**WELWYN HATFIELD BOROUGH COUNCIL
EXECUTIVE DIRECTOR - PLANNING, PUBLIC PROTECTION AND GOVERNANCE**

DELEGATED APPLICATION

Application No: 6/2018/1274/HOUSE
Location: 16 Daffodil Close Hatfield AL10 9FF
Proposal: Erection of a two storey rear extension and conversion of garage into a habitable room.
Officer: Mr Richard Sakyi

Recommendation: Granted

PROPOSED REAR ELEVATION

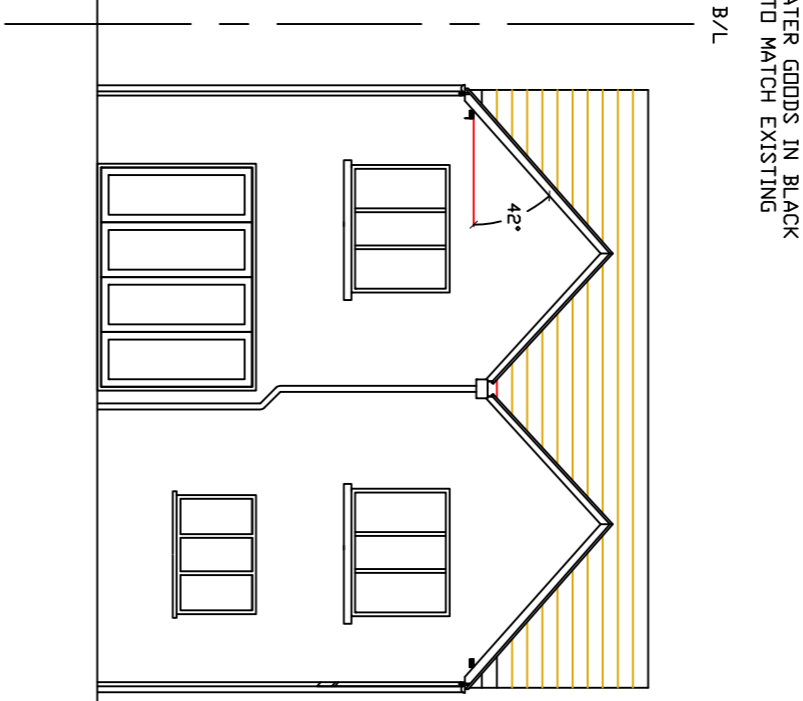
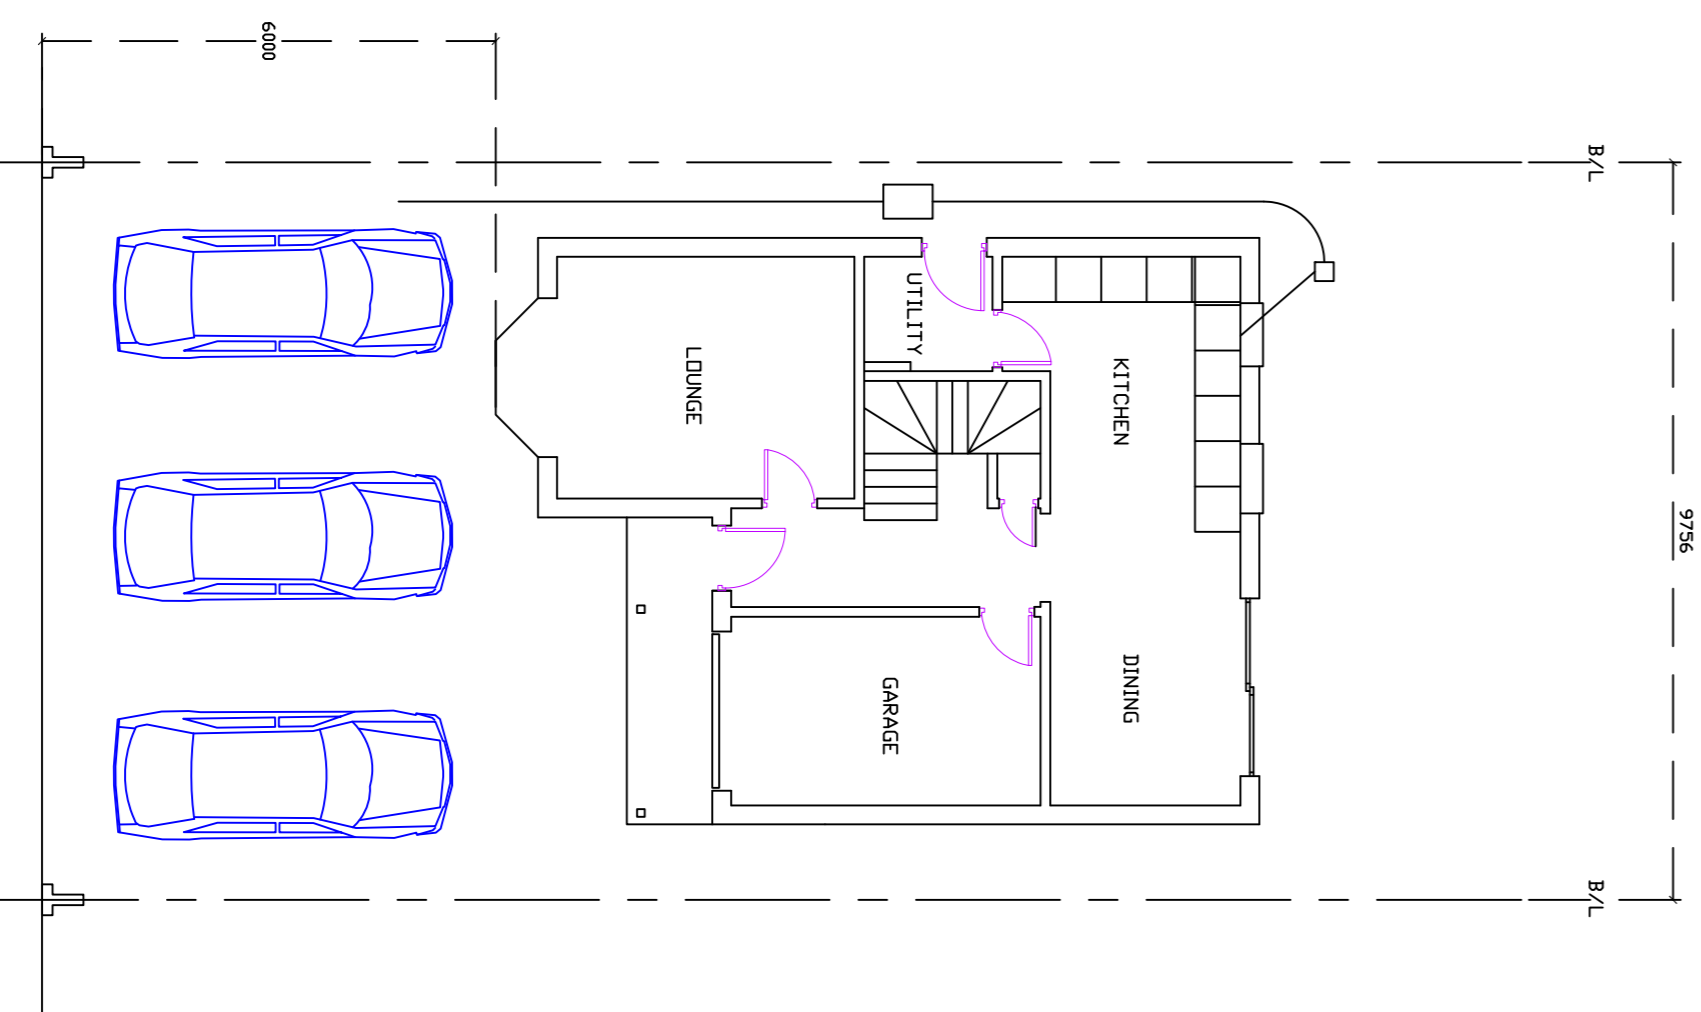
| Design (form, size, scale, siting) and Character (appearance within the streetscene) | <p>The design, size and siting of the proposed two-storey rear extension is considered acceptable. This was also considered acceptable in the previous application and did not form part of the reason(s) for refusal. The external dimensions are identical with matching external materials to reflect those of the existing.</p> <p>It is therefore considered that the proposed development would not have any significant adverse impact on the character of the area.</p> | | |
| Impact on neighbours | The proposed conversion of the garage to habitable accommodation is considered acceptable and would not have any impact on the neighbouring properties by virtue of its location, size and use. The proposed two-storey rear | | |

| | <p>extension would project beyond the rear walls of the adjoining properties however by reason of its orientation, size and siting, there would be no significant adverse impact on the present level of amenity enjoyed by these occupants to warrant the refusal of planning permission.</p> <p>Number 18 and 14 Daffodil Close both have rear conservatories in place however it is not considered that the proposed rear extension would have any adverse impact in terms of loss of light, overbearing of or loss of outlook to warrant the refusal of planning permission.</p> |

PROPOSED GROUND FLOOR PLAN

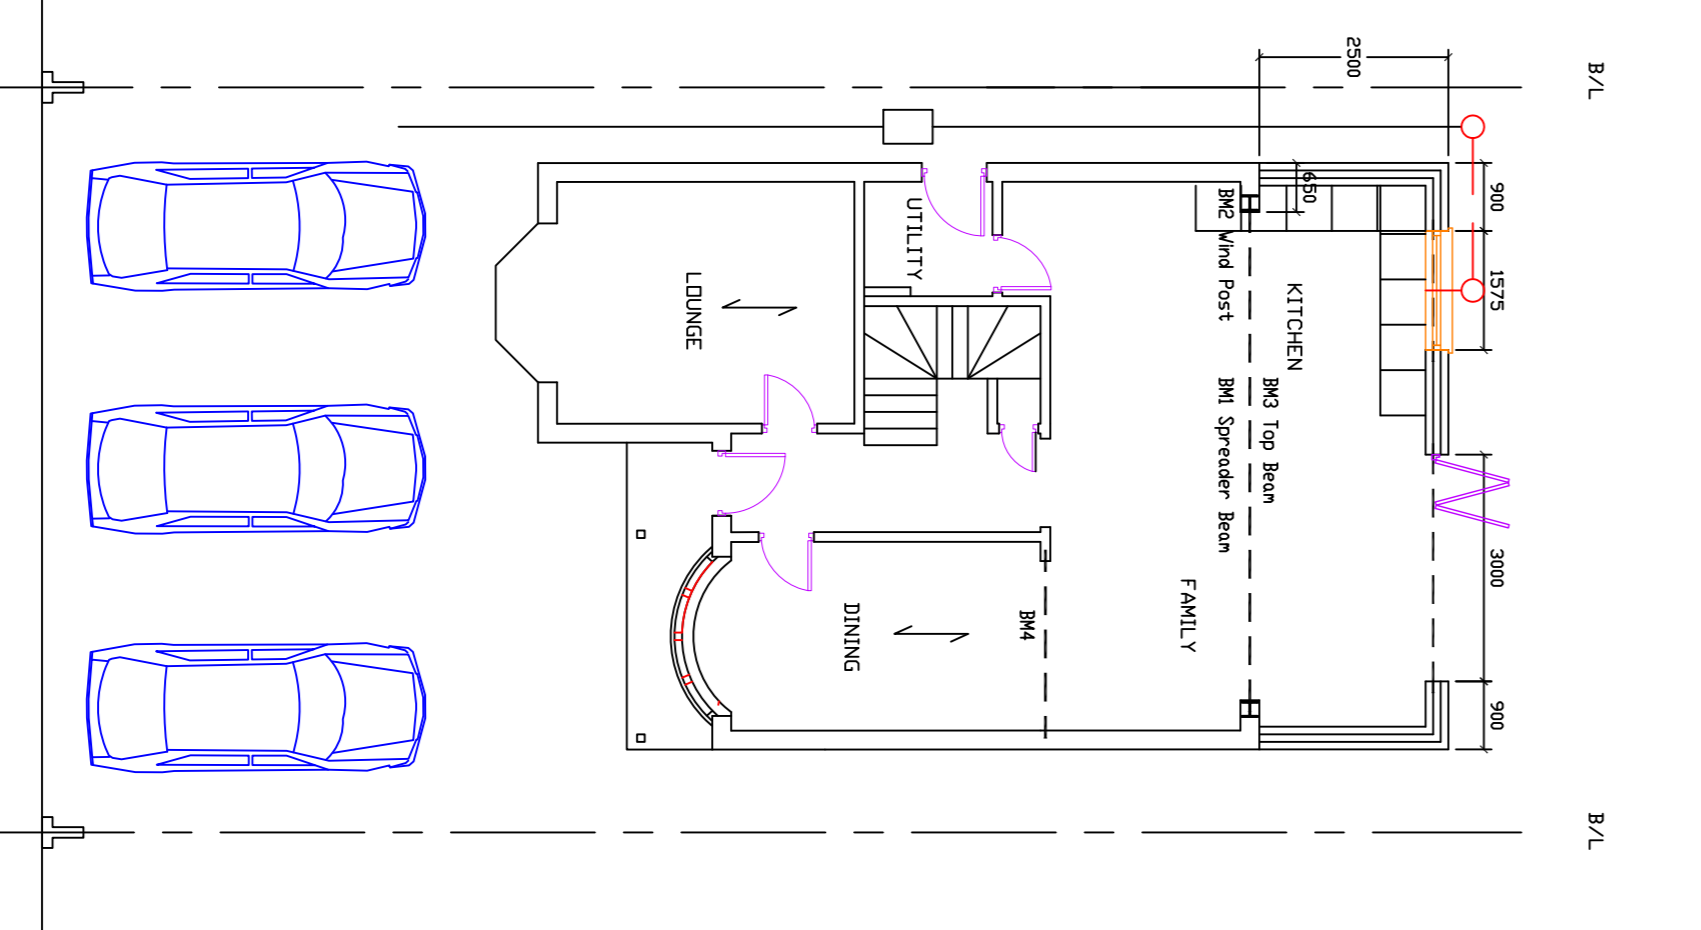
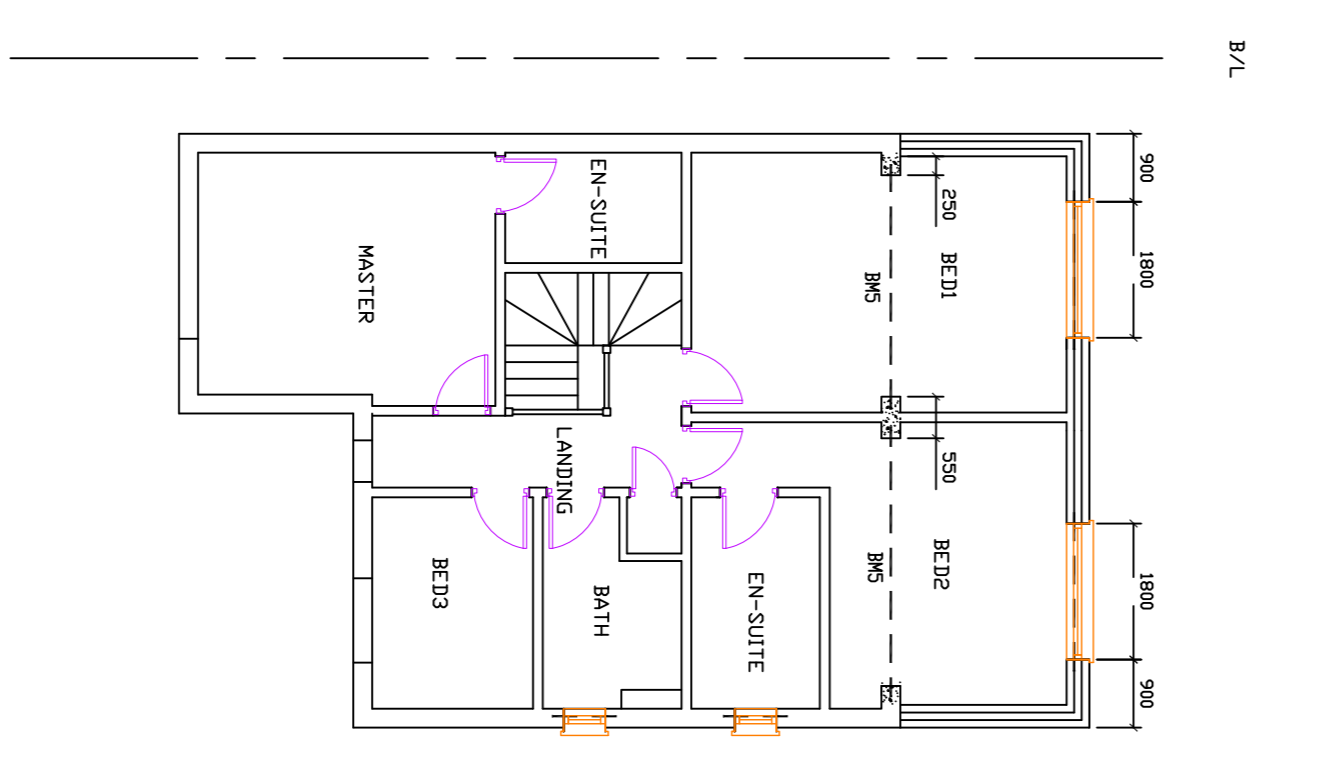
| <p>Access, car parking and highway considerations</p> | <p>The previous application was refused on the grounds that the proposal would lead to the loss of one off street parking space as a result of the loss of the use of the existing garage, which in turn would increase the pressure for on road parking incompatible with the character of the area.</p> <p>The dwellinghouse, as originally designed, has a provision of three car parking spaces - one single space within the garage and two parking spaces on the hardstanding in front of the garage which is an integral part of the design of this development.</p> <p>The current proposal as amended would now retain the amount of parking spaces (3 no.) within the forecourt area of this four bedroom dwelling and as such considered acceptable. The loss of the use of the existing garage would be offset by the provision of additional parking space within the site. It is recommended that a condition be imposed to ensure that the additional car parking space is laid out as depicted on the submitted plan to ensure adequate parking provision within the site.</p> <p>The proposal is therefore acceptable and complies with Policies D1, D2 and M14 of the Welwyn Hatfield District Plan 2005. It is further considered that the proposals have now overcome the previous reason for refusal as assessed under application reference 18/0020/HOUSE.</p> |

BLOCK PLAN
 SCALE 1 : 500 @ A1

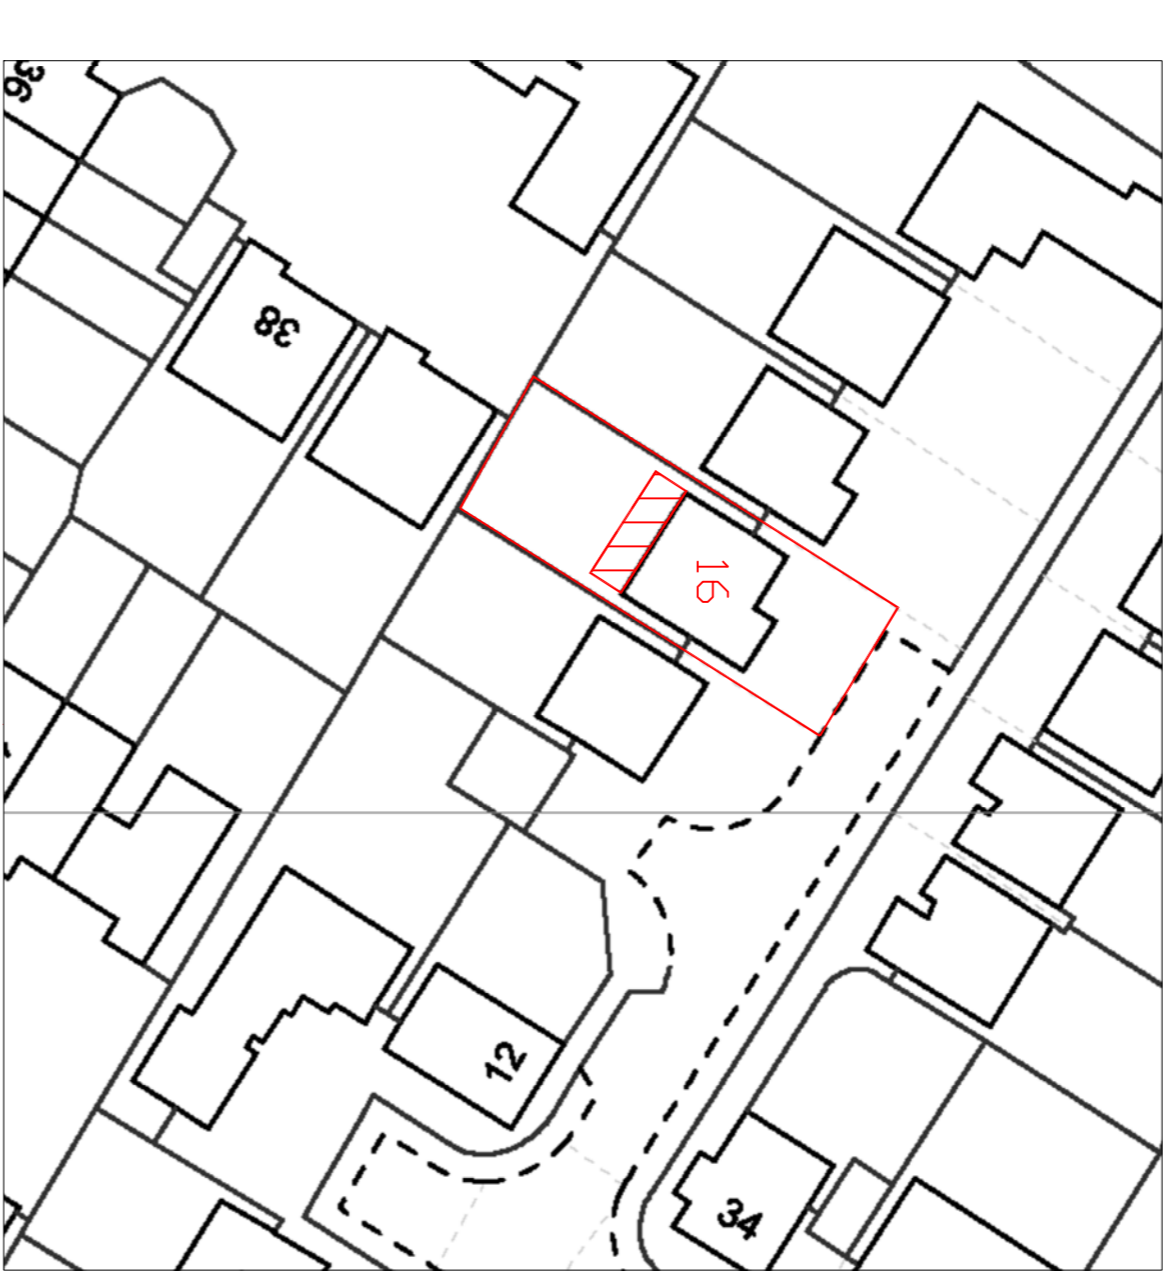
| <p>Landscaping Issues</p> | <p>Local Plan Policy D8 requires landscaping to form an integral part of the overall design, and in this respect the high quality design required by Policy D1 and D2 would again be relevant. Landscaping is important in order to protect and maintain, or ideally enhance, the existing character of the area and to reduce the visual and environmental impacts of the development. It is important that an appropriate balance between hard and soft landscaping is maintained and the Council will aim to ensure that a proportion of the site frontage is retained as landscaped 'greenery' to reduce the visual prominence of hard surfacing and parked vehicles.</p> <p>In this case, the proposed additional parking space would result in an increase in the amount of hardstanding to the front of the site and the loss of a small but valuable area of soft landscaping. Increased levels of hardstanding to accommodate car parking can degrade the quality, character and appearance of an area. Also, no details have been provide in terms of how surface water would drain from the extended parking area. To reduce surface water run-off the parking area should be a laid with a permeable surface, or alternatively drain to a soft landscaped area.</p> <p>No landscaping details have been provided, therefore, it would be reasonable to attach a planning condition requiring a detailed landscaping scheme to be submitted and approved by the Local Planning Authority in order to reduce the visual and environmental impacts of the development. A landscaping scheme</p> |

1. The area set aside for car parking shall be laid out and surfaced in accordance with a scheme which has been submitted to and agreed in writing by the Local Planning Authority before the extension hereby permitted is first brought into use and shall be retained permanently thereafter for the free parking of vehicles for residents/occupiers of the development permitted and shall not be used for any other purpose.

2. No development shall take place until full details on a suitably scaled plan of both hard and soft landscape works have been submitted to and approved in writing by the Local Planning Authority. The development shall not be carried out other than in accordance with the approved details.
